Rezoning Petition Review

Rezoning Petition #: 08-67

Location of Property: Approximately 1.69 acres located on the east side of Colwick Rd between Chiswick Road and Greenwich Road

TITLE:
CONCEPTUAL SITE PLAN

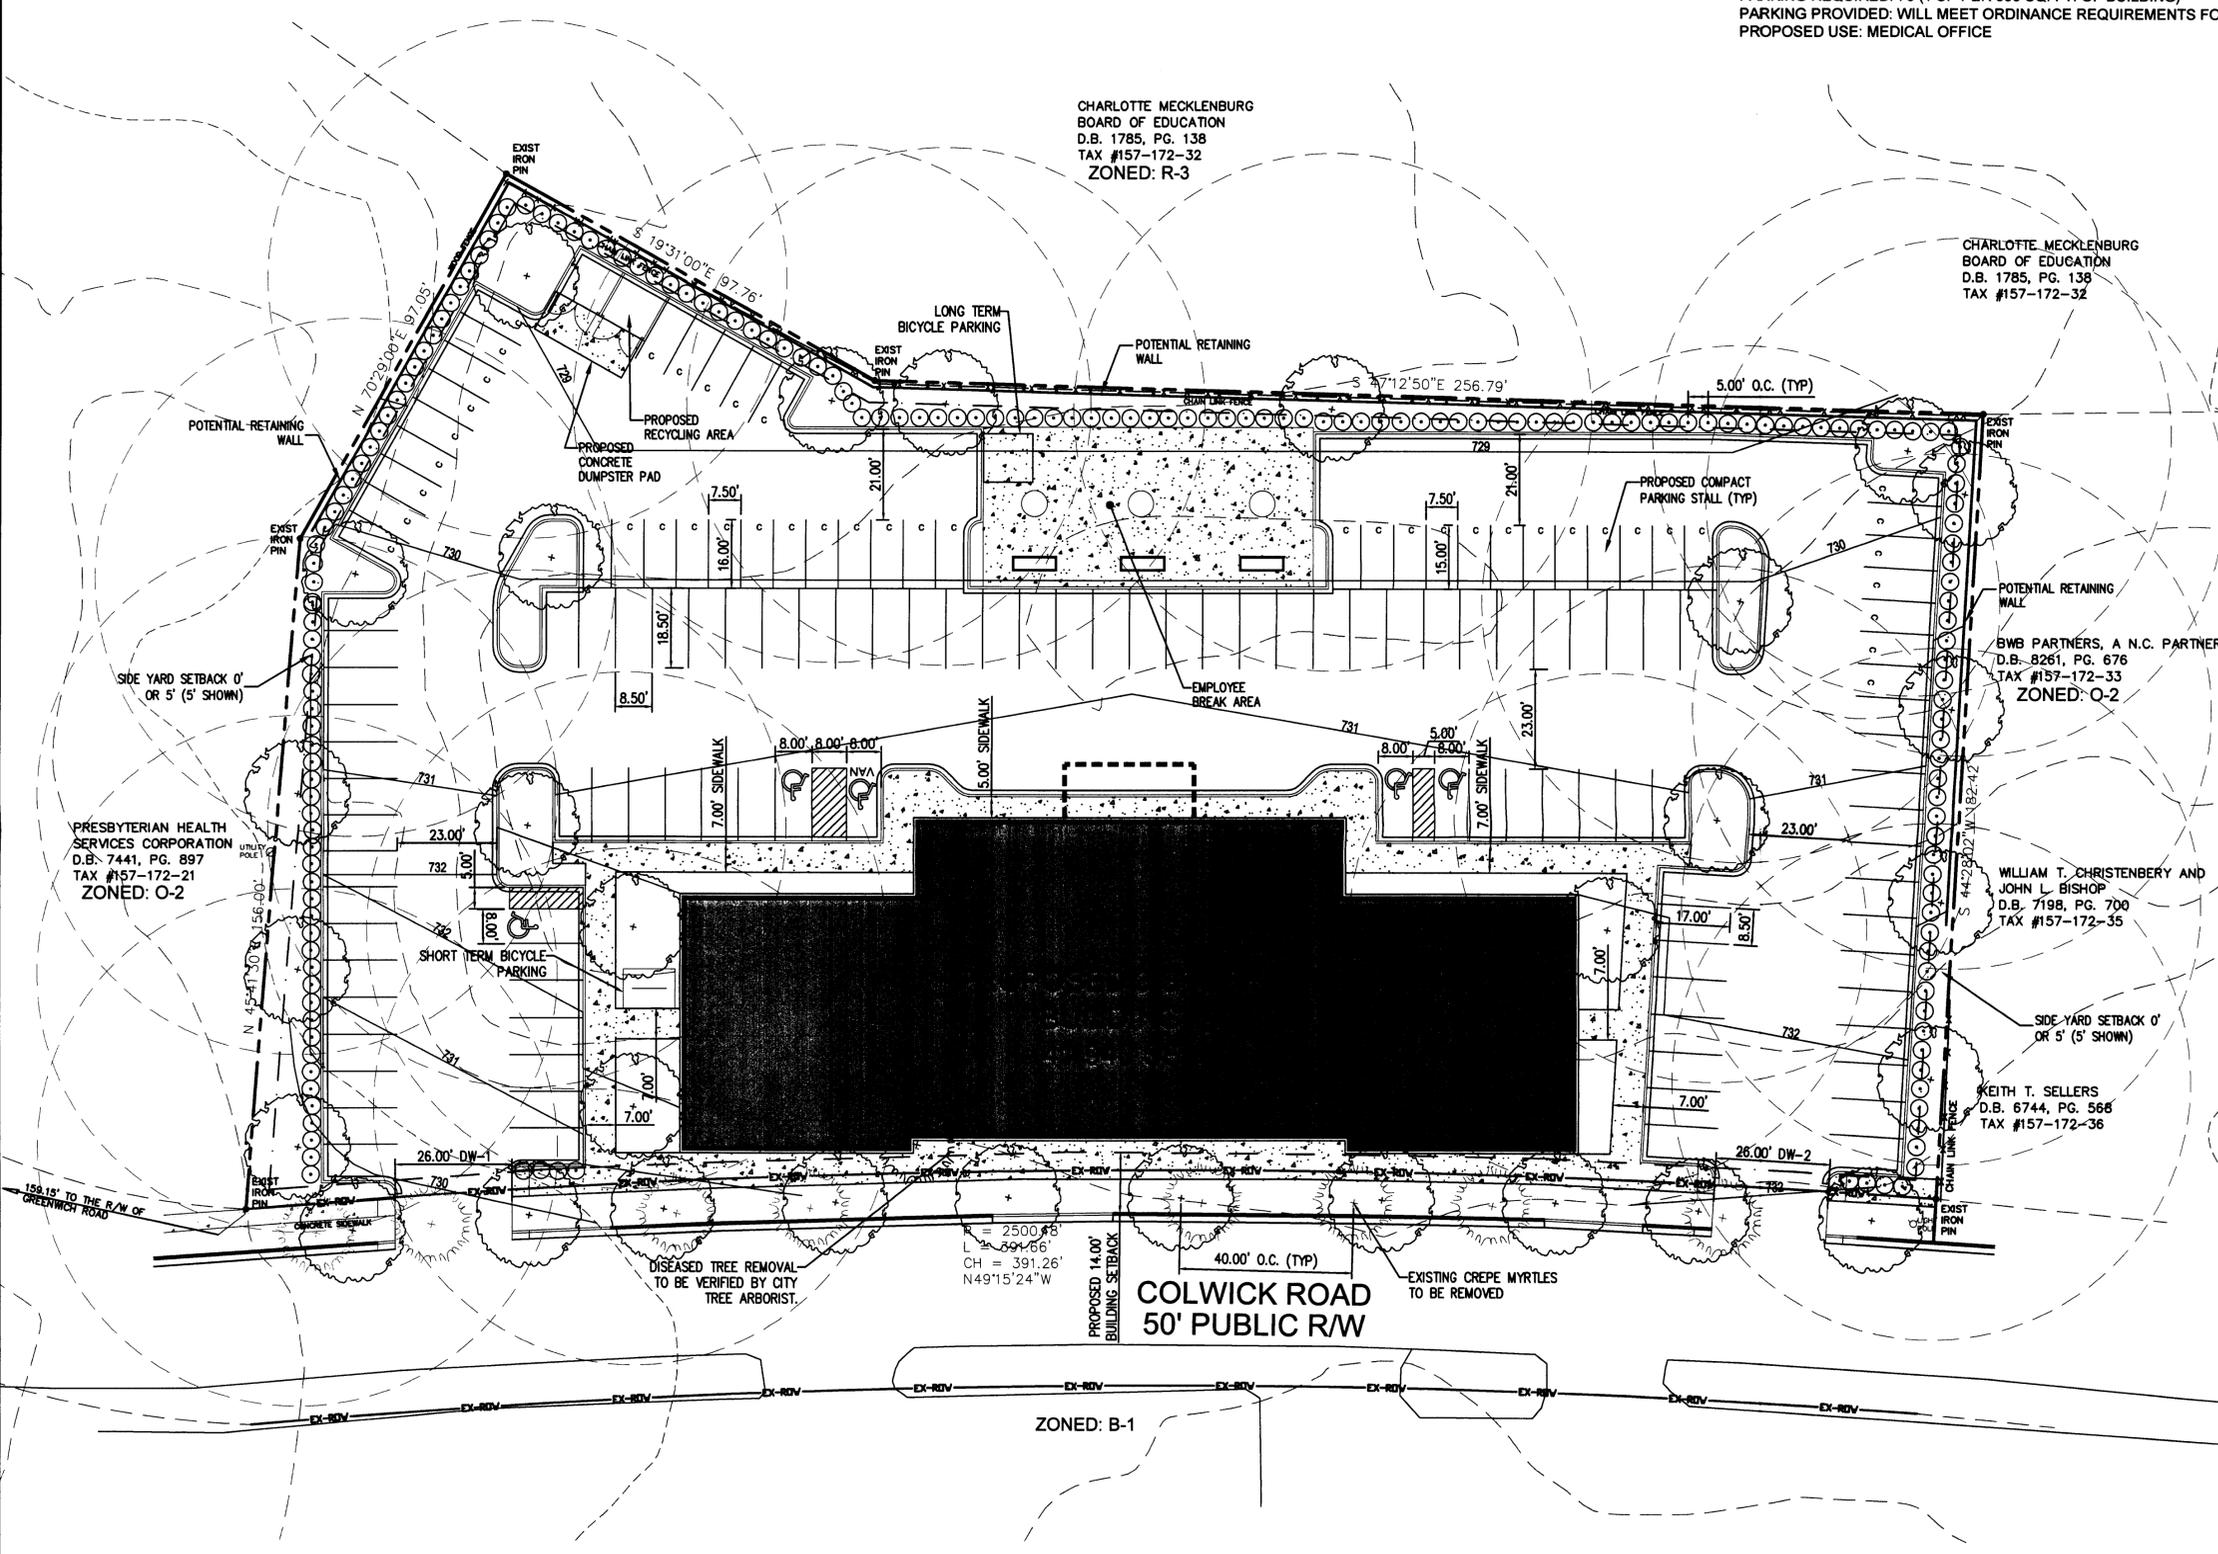
Downstream Complaints and analysis: This site drains to a stream listed as impaired by the NC Division of Water Quality.

Concerning Storm Water: Include the following notes on the petition.

The petitioner shall comply with the Charlotte City Council approved and adopted Post Construction Controls Ordinance.
